My ref: RLS/18.02/17/AR

Your ref: A/87/18/PL

26th July 2018

Proposed Single Dwelling: Land at the Ninth Tee, Ham Manor Way, Angmering.

Site Plan (1:500)

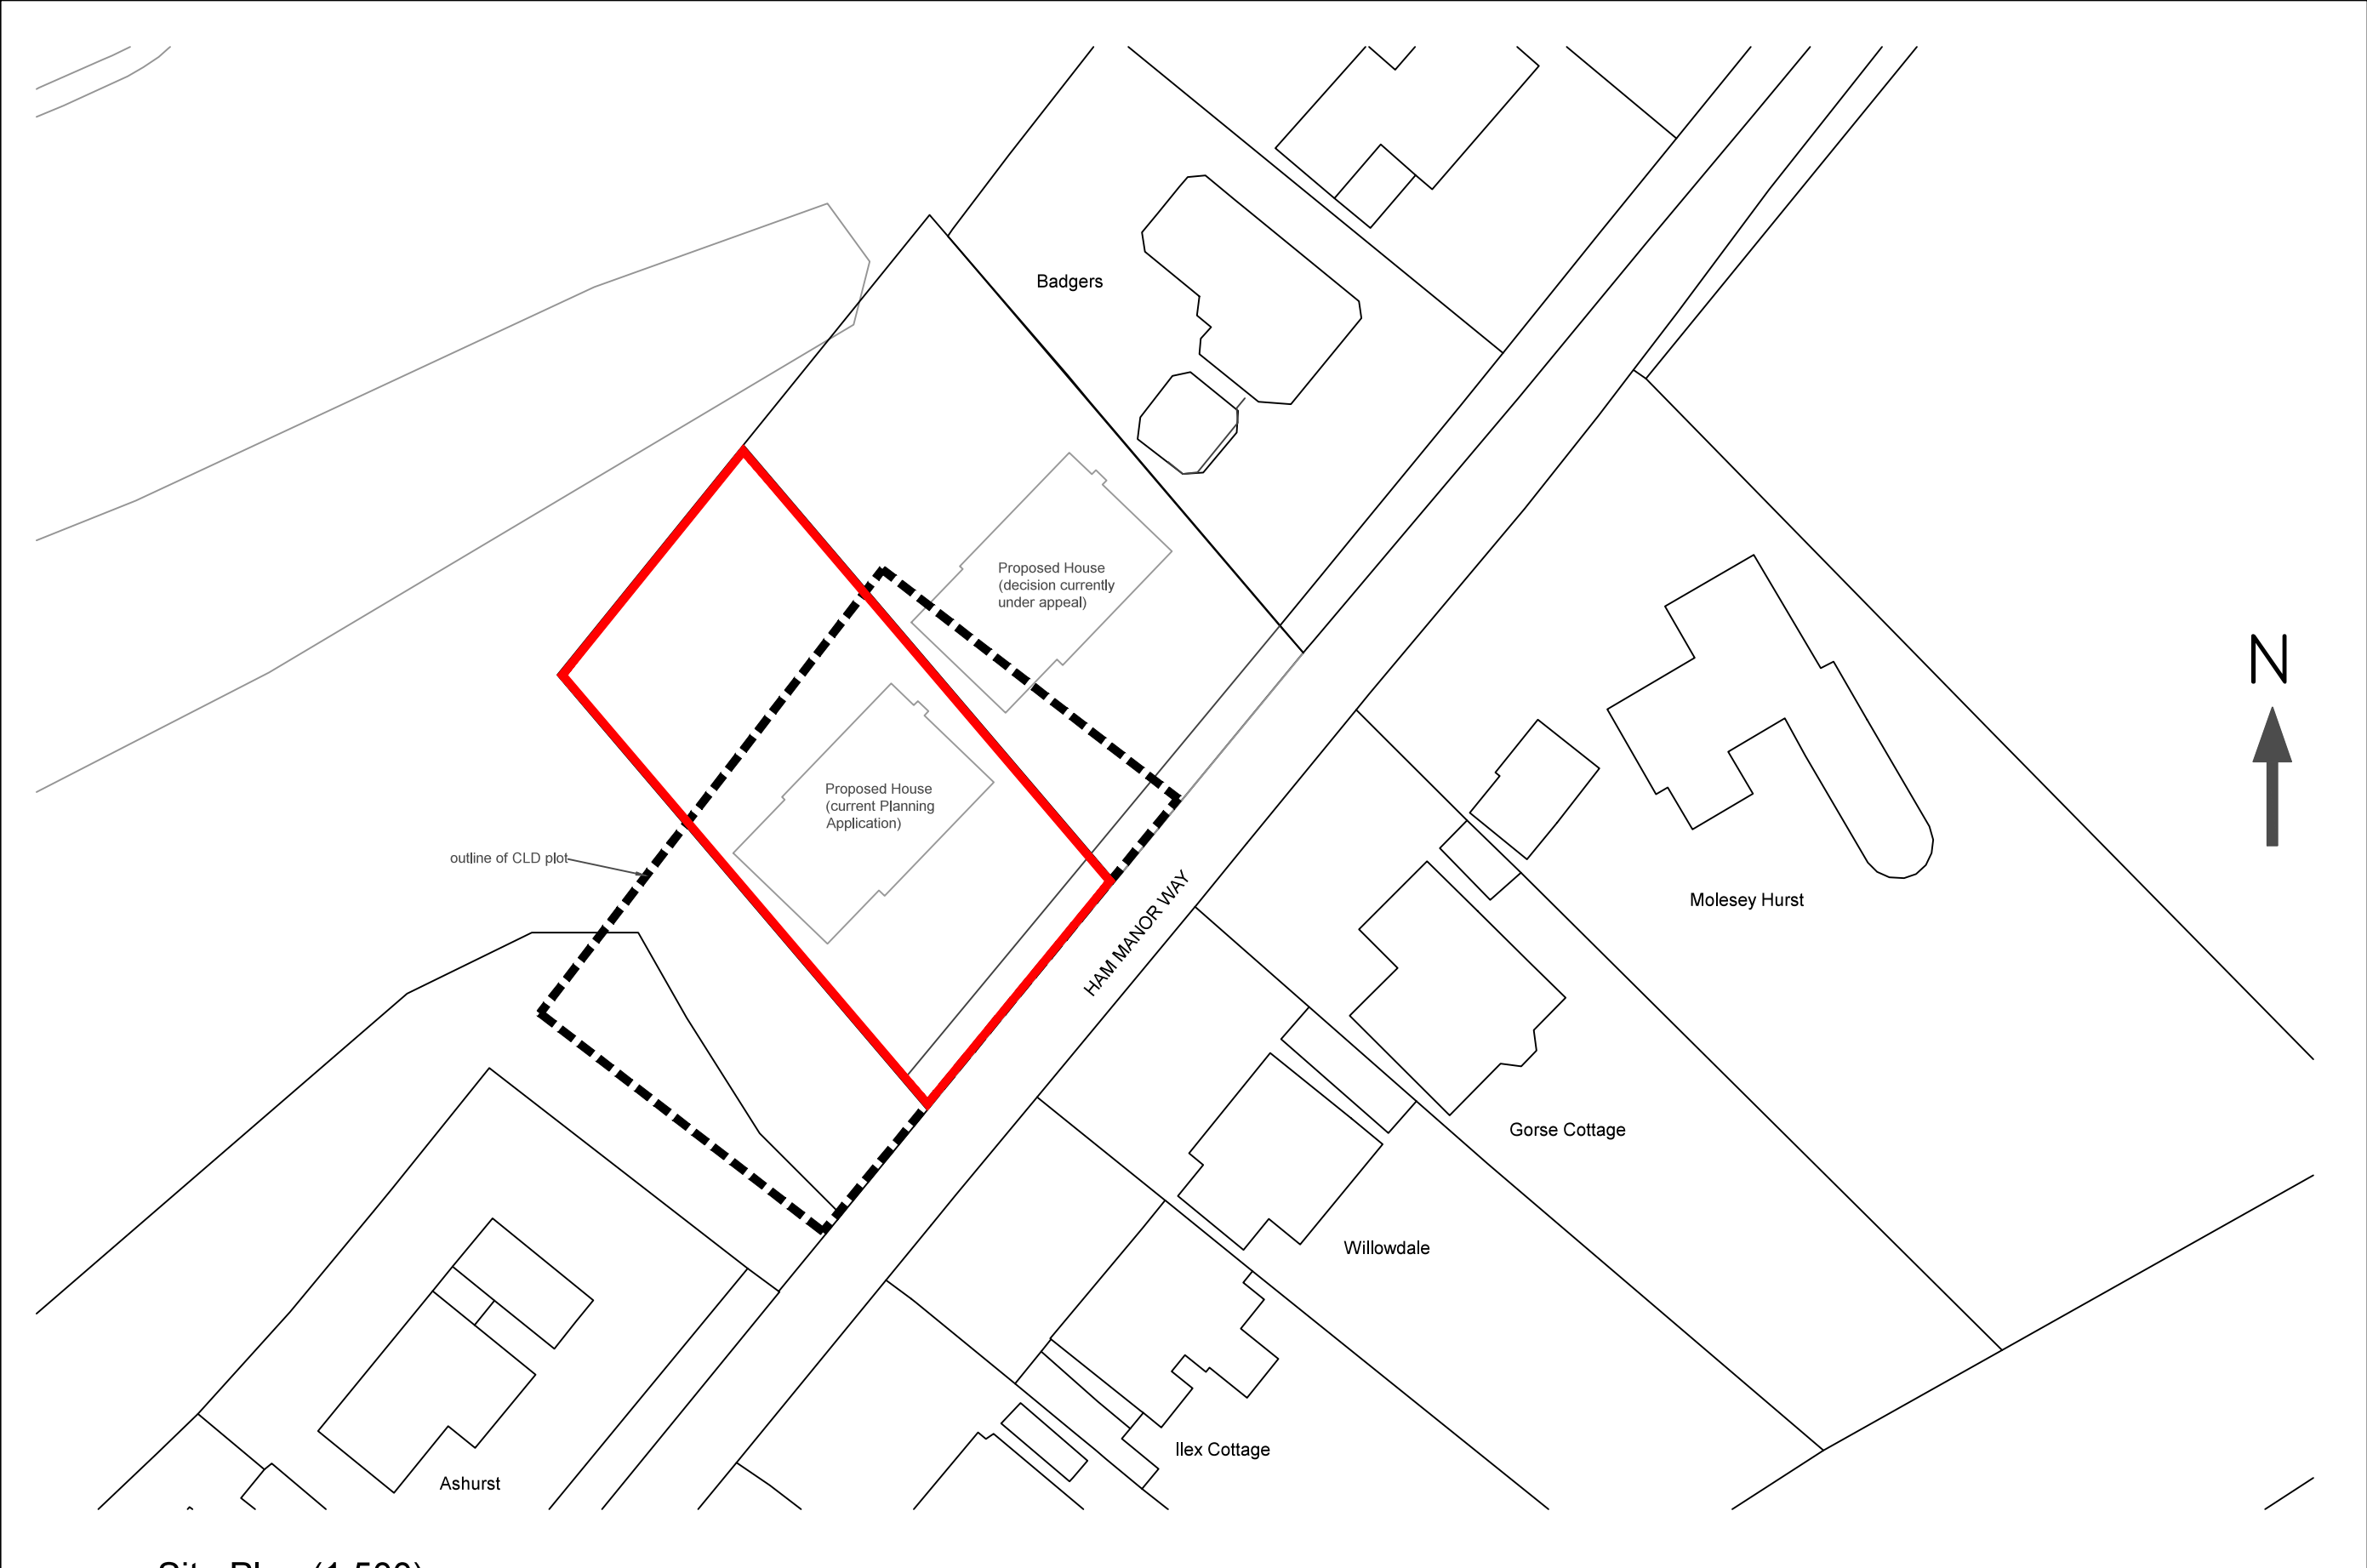
I will leave you now to duly reflect upon the matters raised in this letter. In terms of the principal issue as raised this application should clearly be refused as it extends the garden area to the rear well beyond the land allocated under the CLP into protected Local Green Space into the Countryside beyond and must therefore be contrary to the provisions of the Development Plan which are in themselves up to date. There is also the intention of the applicant, which I maintain is clearly material to his decision-making, in looking to expand the nature of the development in either direction to the north and south which will have a grossly unacceptable effect upon my clients who live and adjoin this site in the context that for many many years this open space has remained undeveloped and free of future housing to their outlook and enjoyment.
